14 March 2022

SSD7348 MOD 10, OAKDALE WEST STAGE – S.4.55(1A) APPLICATION TO MODIFY ARCHITECTURE PLANS

2.1.1 Estate Masterplan (OAK MP 02) update

2.1.3 Signage Precinct 1 Plan (OAK MP 12) Update

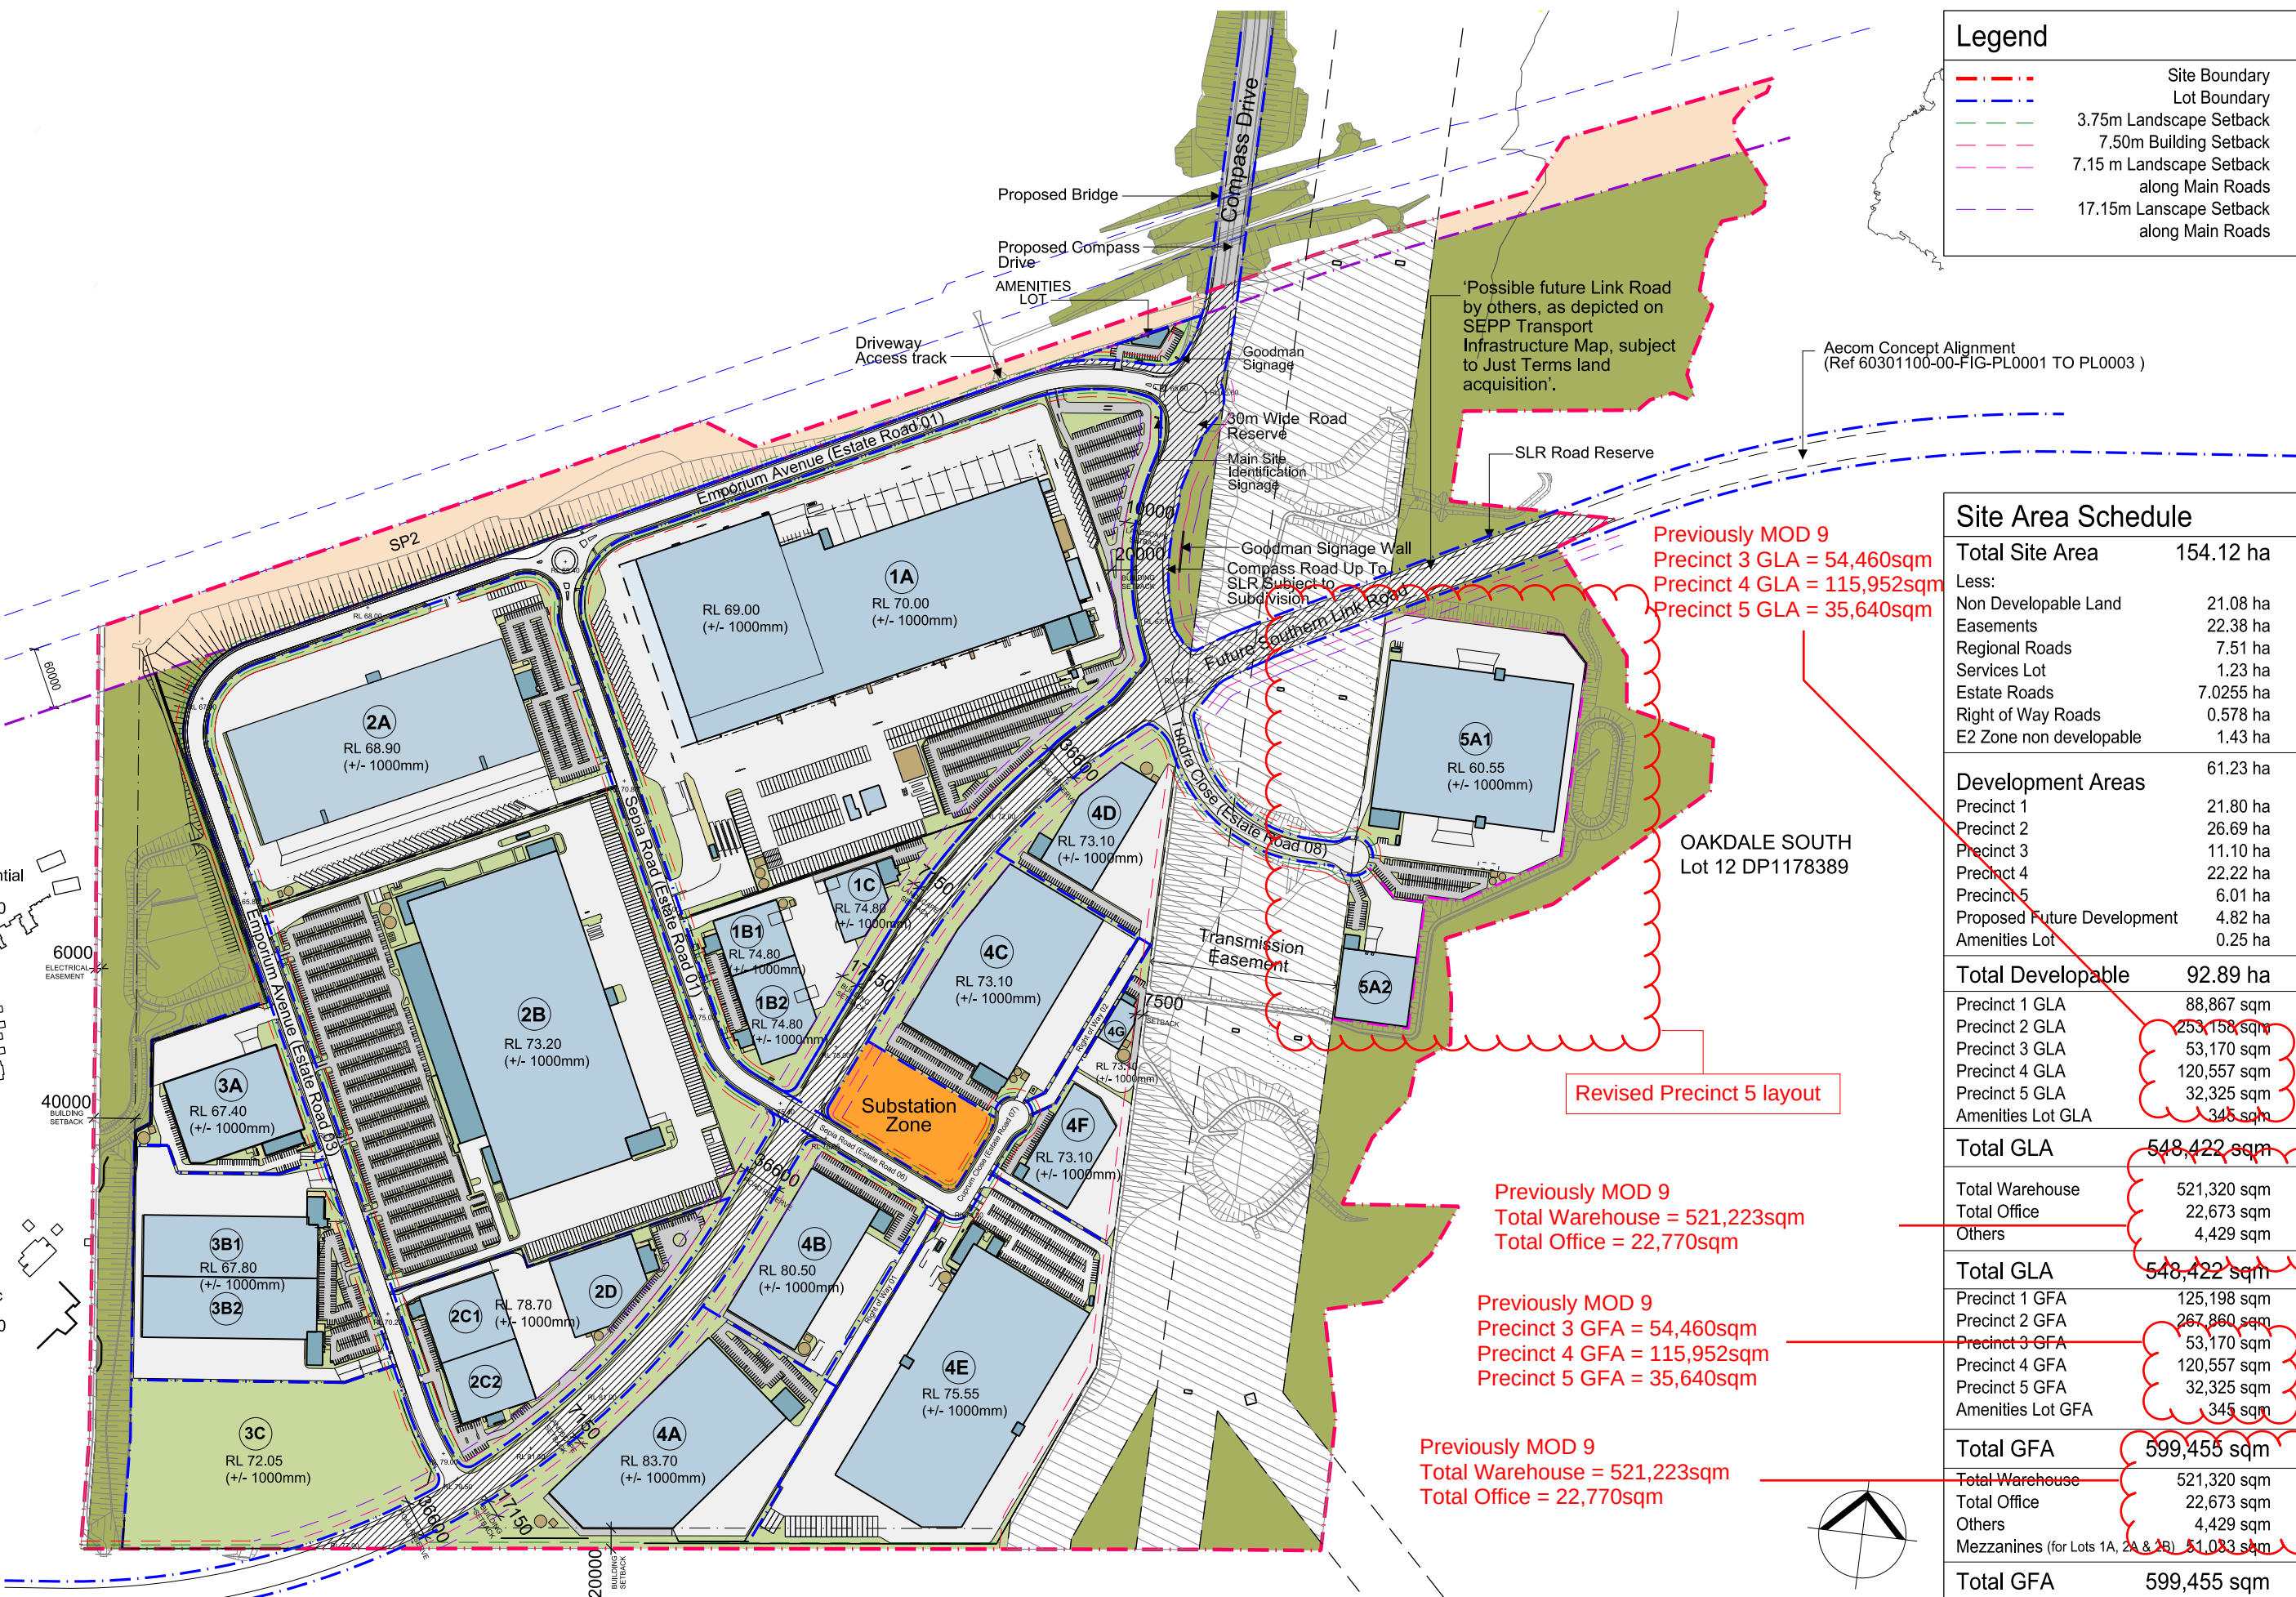
- 1) GFA schedule updated:
 - Nominal increase in total warehouse GFA from 521,223sqm to 521,320sqm; and reduction in office GFA from 22,770sqm to 22,673sqm
 - This update results from minor GFA changes for Precincts 3,4,5 (subject to separate SSD / DA approvals).
 - This masterplan update is required to ensure consistency with recently approved for Warehouse 4E, and a proposed DA to Penrith Council for Warehouses 3C and Precinct 5.
 - Council requires OWE DA lodged to be consistent with the masterplan, hence the requirement to update the masterplan layout.
 - It is noted the total GFA for OWE remains unchanged.

Revised Precinct 5 layout

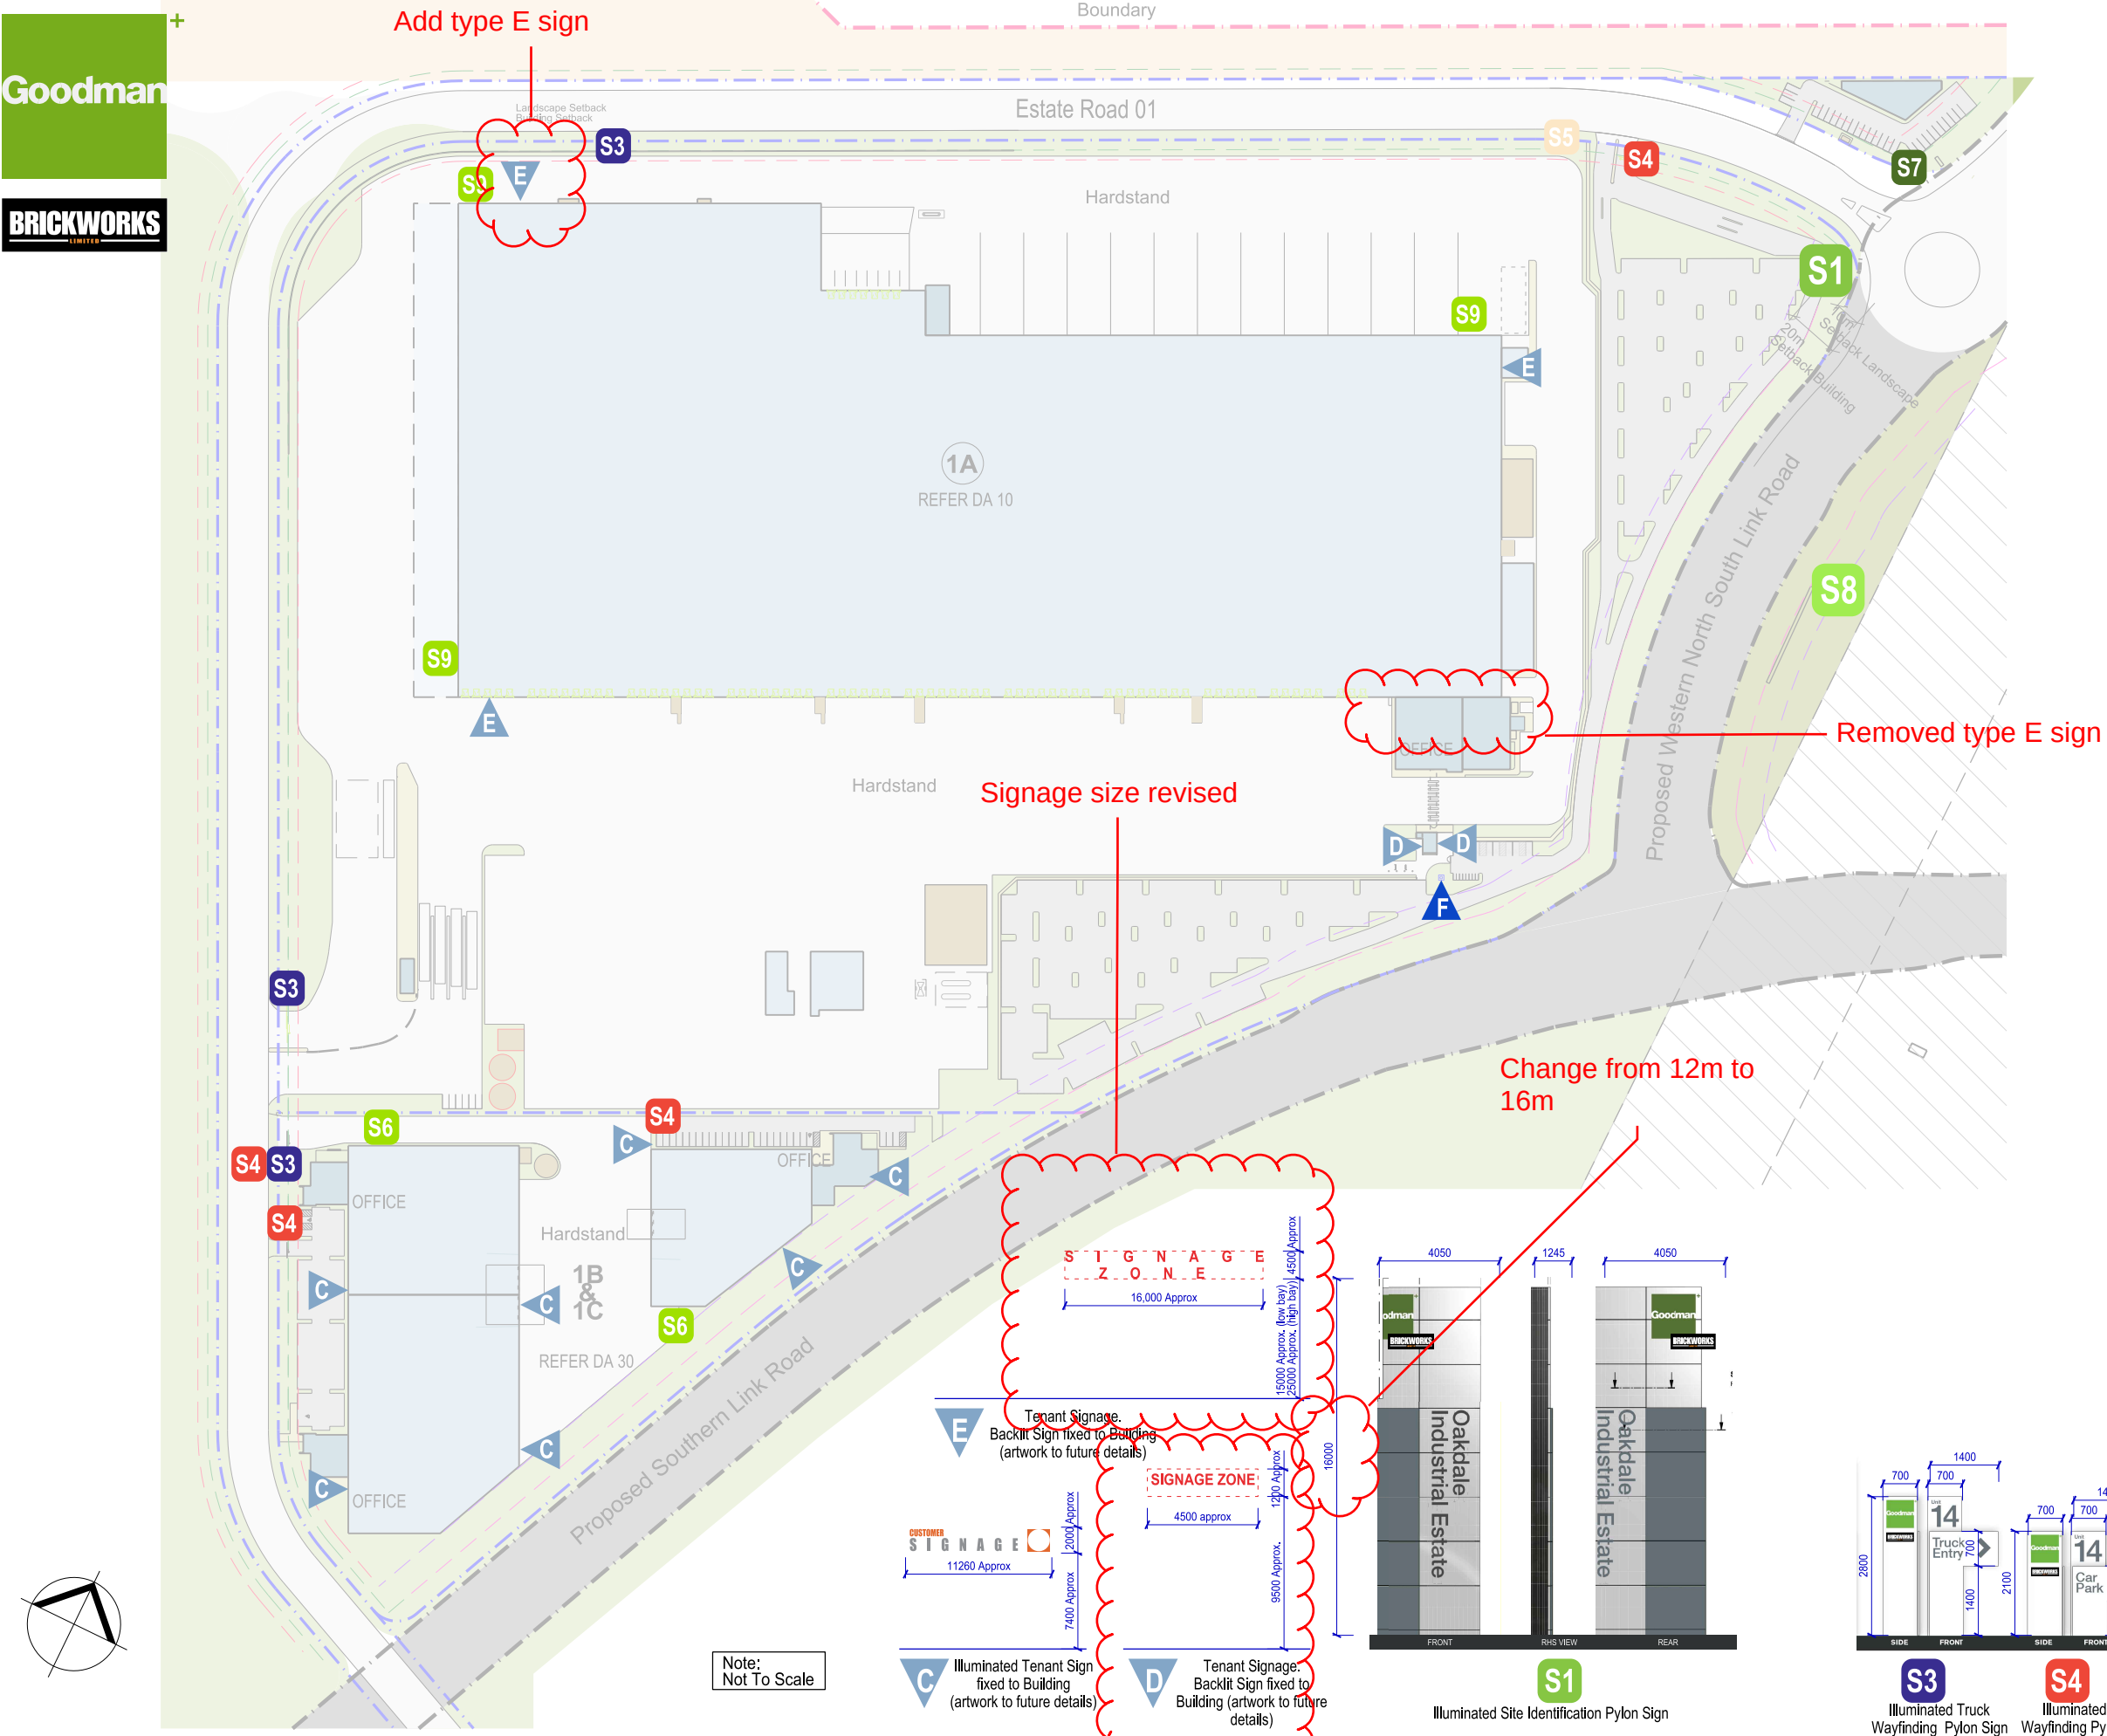
2.1.2 Update to Precinct 5 layout

- Reduce the size of primary warehouse, shown as warehouse 5A in approved concept plan) and the addition of a new small warehouse (Warehouse 5A2).
- This layout update is to reflect customer demand.
- The update results in a reduced Precinct 5 car parking from 245 spaces to 137 spaces.
- The update results in a GFA reduction from 35,640sqm to 32,325sqm.
- It's noted Precinct 5 is subject to separate Penrith Council DA assessment, to be lodged imminently.
- The layout update is required to ensure consistency between the SSD7348 masterplan and development at Precinct 5
